Application by Equinor for an Order Granting Development Consent for the Sheringham and Dudgeon Extension Projects.

Examination Timetable – Deadline 3

Examining Authority's Written Questions 2

-  90th percentile with 1nm clearance from DEP North
-  90th Percentile (Tees- Zeebrugge)
-  DEP & SEP Extensions

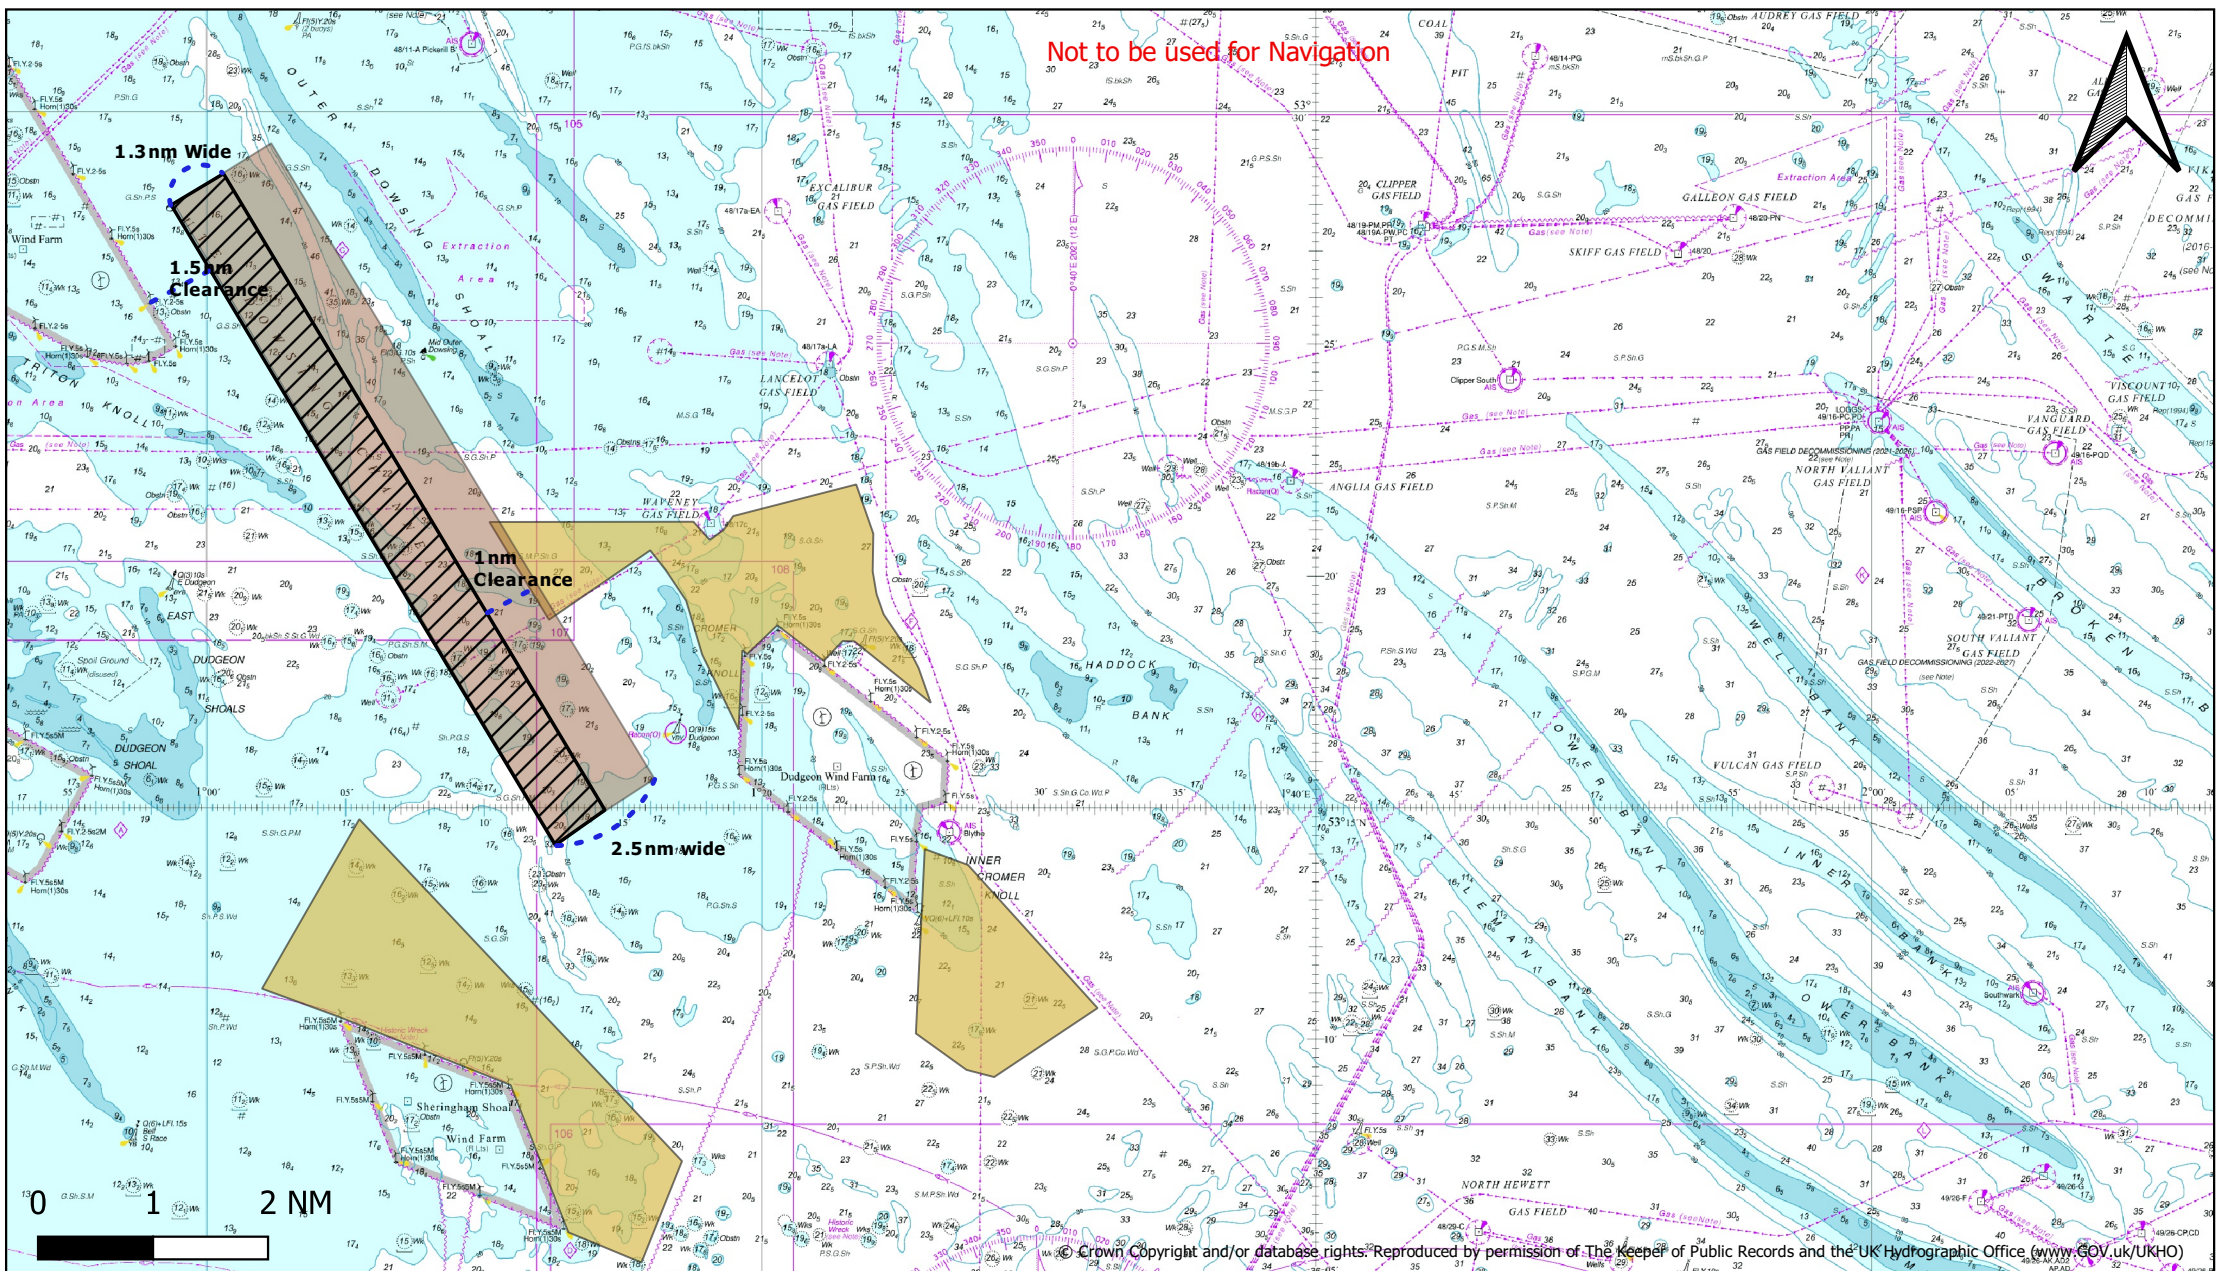
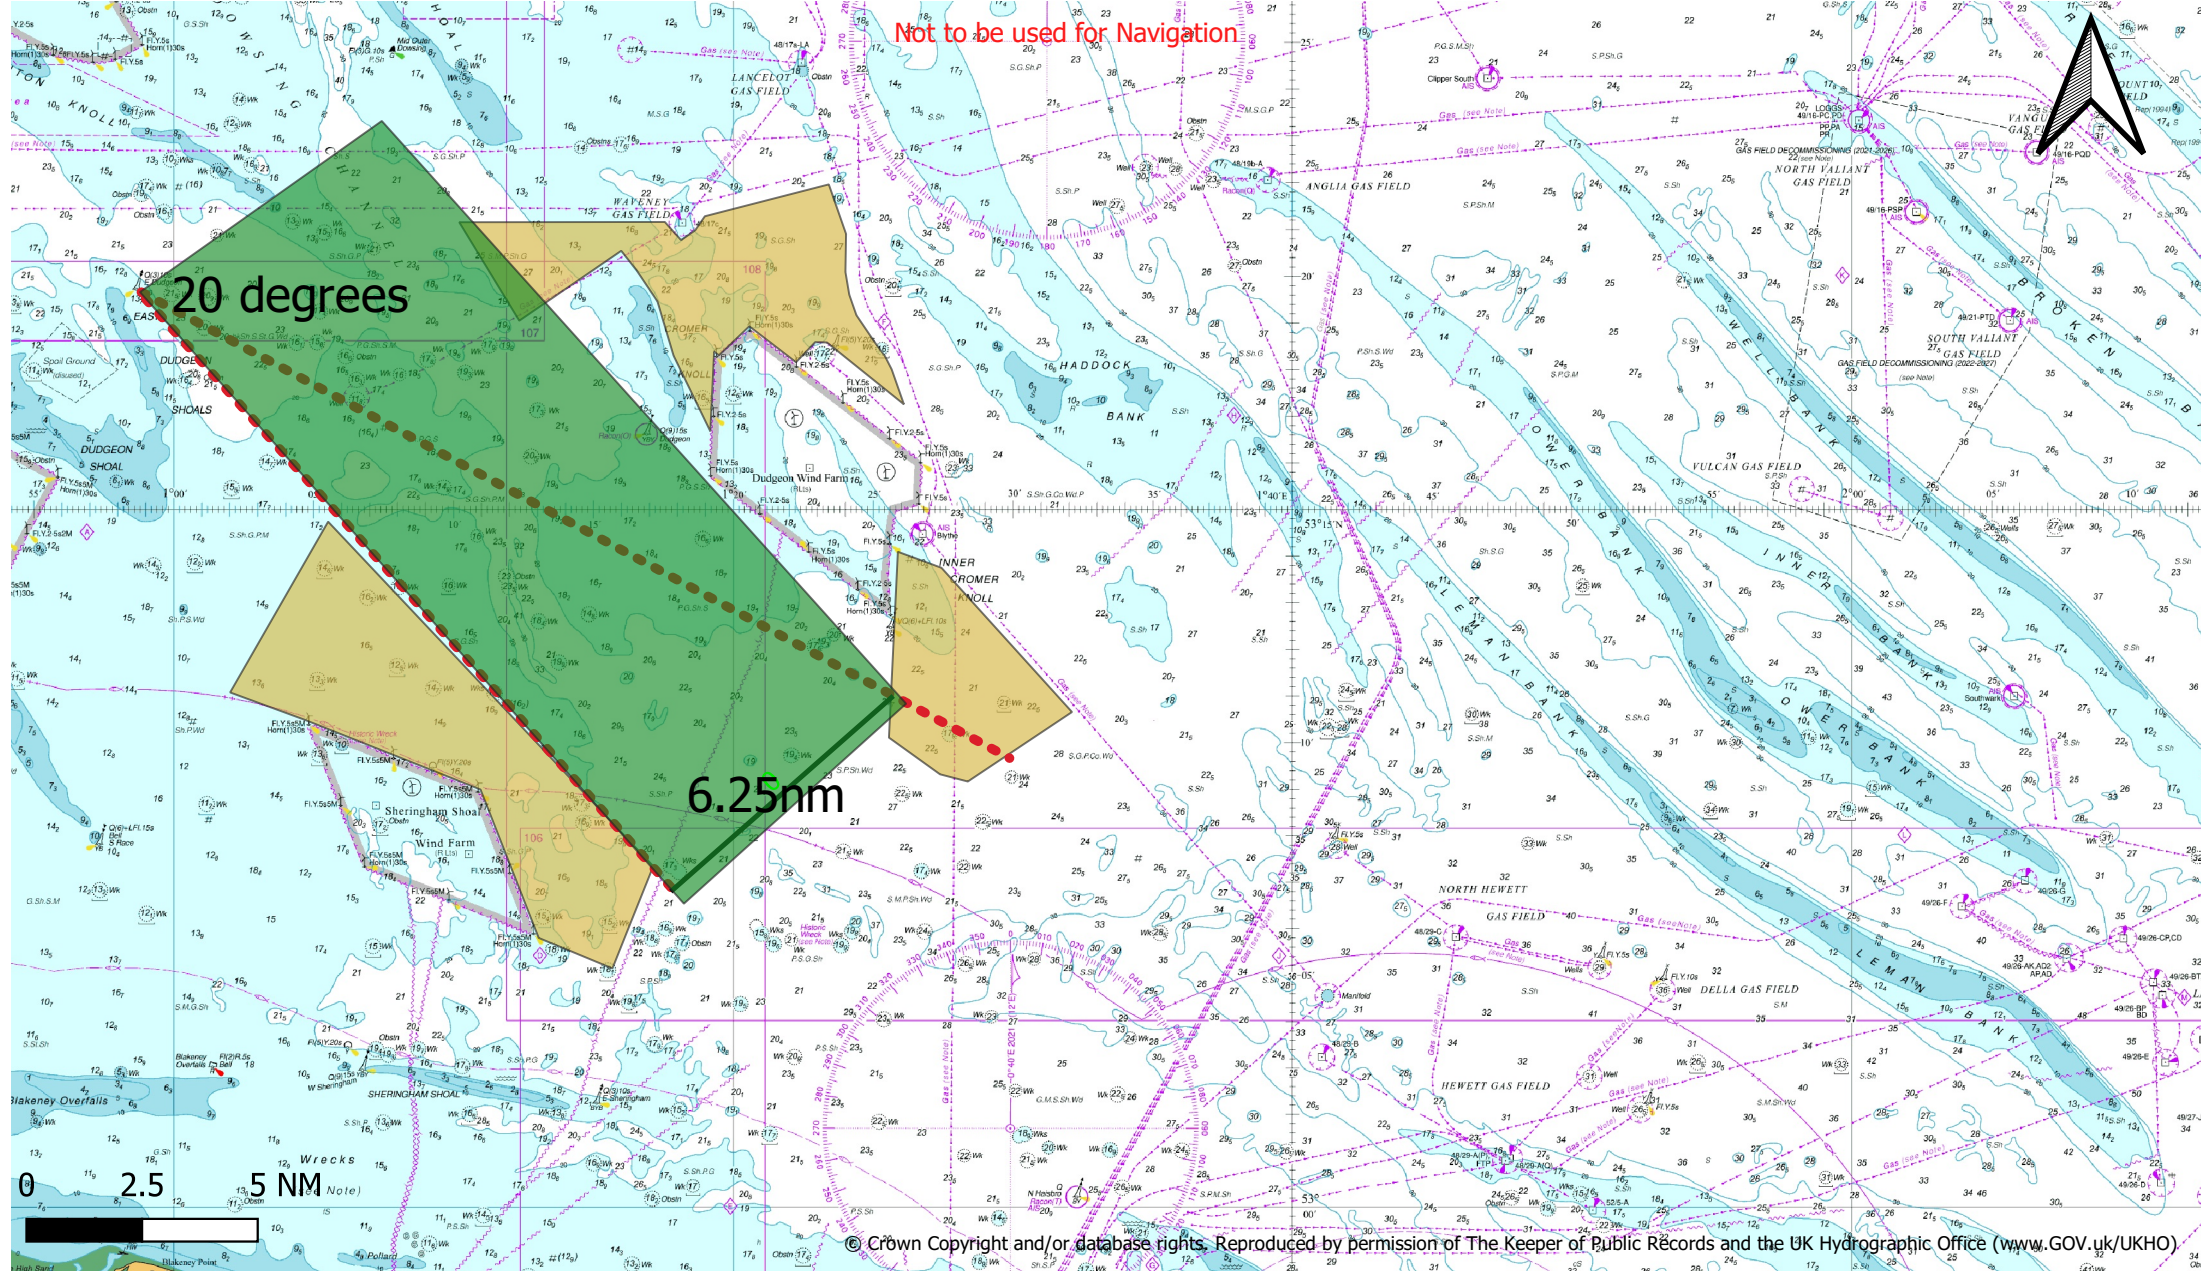
MCA's concern is the loss of sea room to the west of the northern section of the DEP array that will constrict the two-way traffic into a channel with less than half of the current sea space. The complexity of the area must be accounted for when considering the issue around the width of this channel. There are shallow waters both to the east and west of the Outer Dowsing Channel and traffic converges into the gap between SEP and DEP. The orientation of traffic east of Triton Knoll Offshore Wind Farm is not entirely because of the wind farm but due to the shallow waters of Triton Knoll and the Outer Dowsing Shoal and this is a key factor in the traffic restriction into a corridor.

The data within the NRA shows 90% of vessels transiting through the Outer Dowsing Channel do so in a corridor 2.5NM wide (see Image 1 in AS-044). The northern DEP array would push the north bound traffic to the west and MCA has used a conservative figure of 1NM safety buffer. If the recommendation in the guidance document published in 2018 by The World Association for Waterborne Traffic Infrastructure (PIANC), MarCom Working Group Report no. 161-2008, titled "*Interaction Between Offshore Wind Farms and Maritime Navigation*" is followed, this safety buffer would be 1.2NM which is based on the turning circle of a 195m¹ LOA (Length Over All) vessel:

Although the proposed extensions appear to comply with the minimum clearance derived from the guidance (using 195m LOA), the MCA believes that due to the particular circumstances of the area concerned, wider safety parameters should be adopted. The 195m LOA measurement used in the above calculations was taken from a week of AIS data in August 2021. The applicant collected two 14-day traffic surveys in summer and winter and 12 months of AIS data from 2019, and while the NRA does not provide any details on LOA, the 195m figure is likely to be an underestimation. The guidance assumes a central division for vessels heading in opposite directions, in this case north and south. The absence of a sea lane or any traffic separation scheme initiatives in this area is of relevance to our concerns. Traffic can, and does, transit the area in a north and south direction without any obligation to keep to one side or the other.

The restricting factors in the area are the shallower water aforementioned, and the presence of the already existing windfarms. This means that the frequency of encounters for vessels to meet head on are increased. The presence of the northern extension in particular, constricts this traffic in their ability to take early and substantial action in accordance with COLREGS and invites either a departure from them, or alteration of course into the windfarm red line boundary, potentially increasing the risk of allision with a structure. In addition, periods of construction and major maintenance on the turbines closest to the boundary will attract 500m safety zones which potentially constricts the sea space and increases collision risk even further.

The NRA assessed the baseline collision risk within the scoped area as being 'reasonably probable' (1 per 1-10 years) which is already very high. The NRA concludes the increased collision risk is 'remote' (1 per 10-100 years) which again is for the scoped area and not specifically for the area of concern with the western boundary of the northern DEP site. MCA recommends that either structures are not constructed west of a line drawn from the Dudgeon cardinal buoy to the Mid-Outer Dowsing buoy, or a reduction in the red line boundary to this effect.

-  Corridor solid box
-  SEP\_DEP 20 degree Line
-  Proposed SEP& DEP Extensions

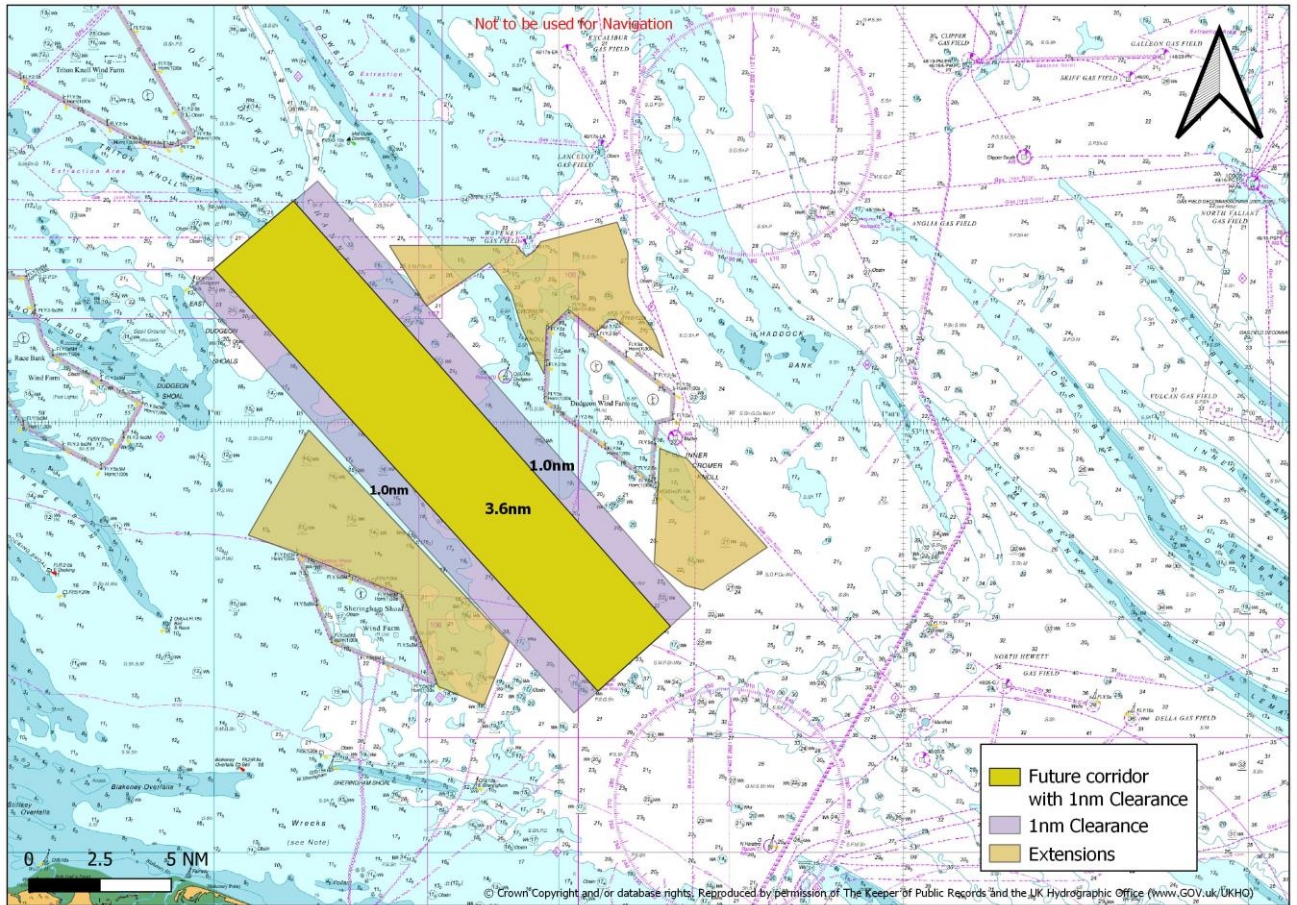
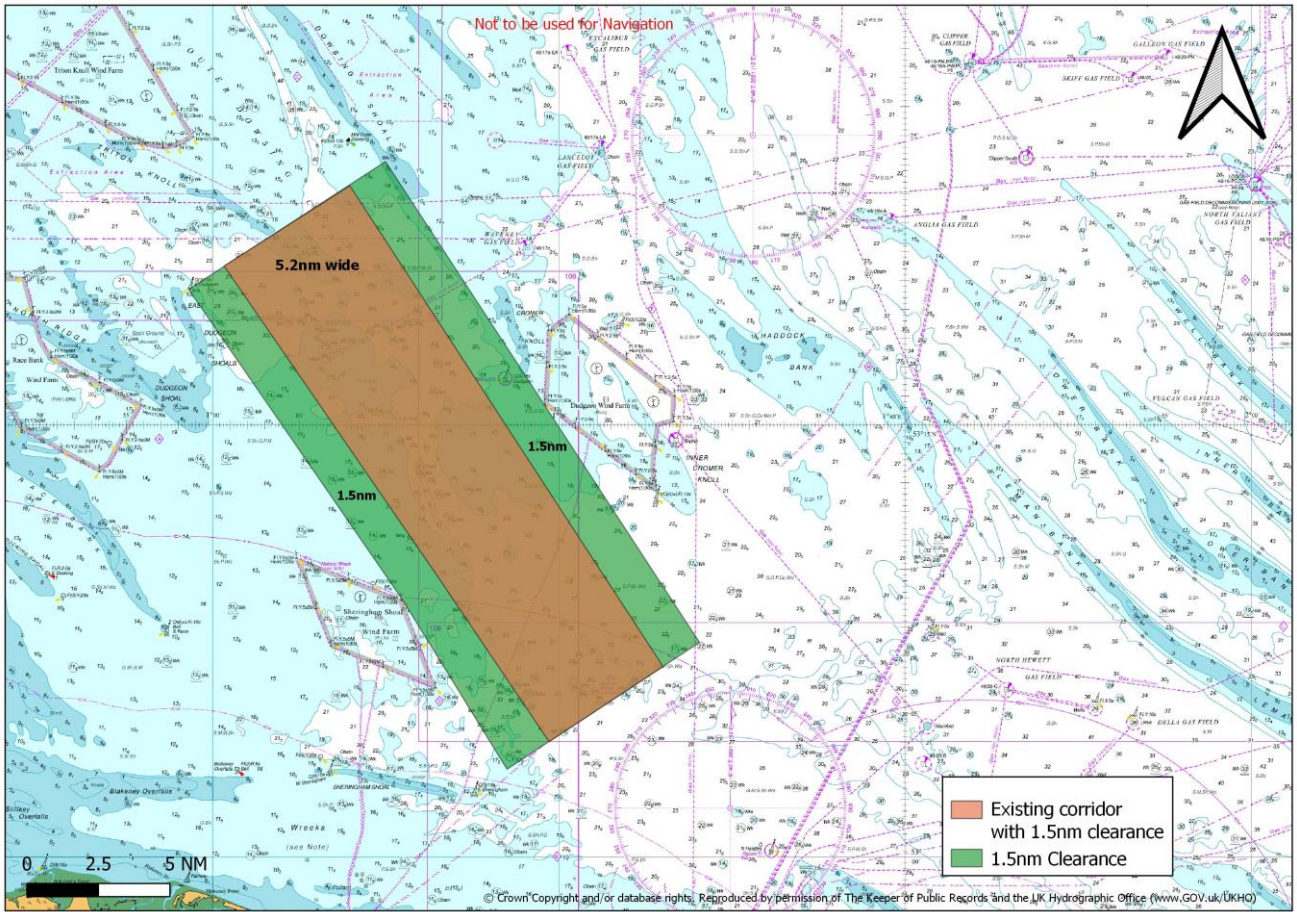
1.3	In Fig 18.1 of the NRA the 20% corridor guidance from MGN 654 has been used to show the minimum width required for the 11.2NM long corridor between the extensions should be at least 4.1NM. The boundaries at the narrowest point are 5.6NM apart, however it is noted that shallow banks marked by the East Dudgeon buoy potentially extend the corridor length a further 6.5NM to the northwest since there is no safe sea room to the west of a line between the East Dudgeon buoy and the northern corner of the Sheringham Shoal Extension boundary. As such, is it arguable the length of the corridor would be 17.2NM and the required width as per the guidance in MGN 654 should be at least 6.25NM.	The NRA [APP-198] included application of the Marine <i>[sic]</i> Coastguard Agency (MCA) methodology for corridor width calculation set out in Marine Guidance Note (MGN) 654, with the strict interpretation of the width requirements being found to be met. In line with the MGN 654 wording, the calculation was based on the area "where turbines appear along both sides of a shipping corridor". It is acknowledged that strict application of the calculation does not account for the presence of the local shallow banks, and text on this basis was included in Section 18.4 of the NRA [APP-198].			The corridor guidance in MGN654 is to be used for determining safe distances between wind farms boundaries and shipping routes on a case-by-case basis. Factors that should be considered, in addition to the 20-degree model, are described in Section 4.7 in MGN654. It is important to recognise that the corridor guidance and shipping route template are not prescriptive tools but need intelligent application.
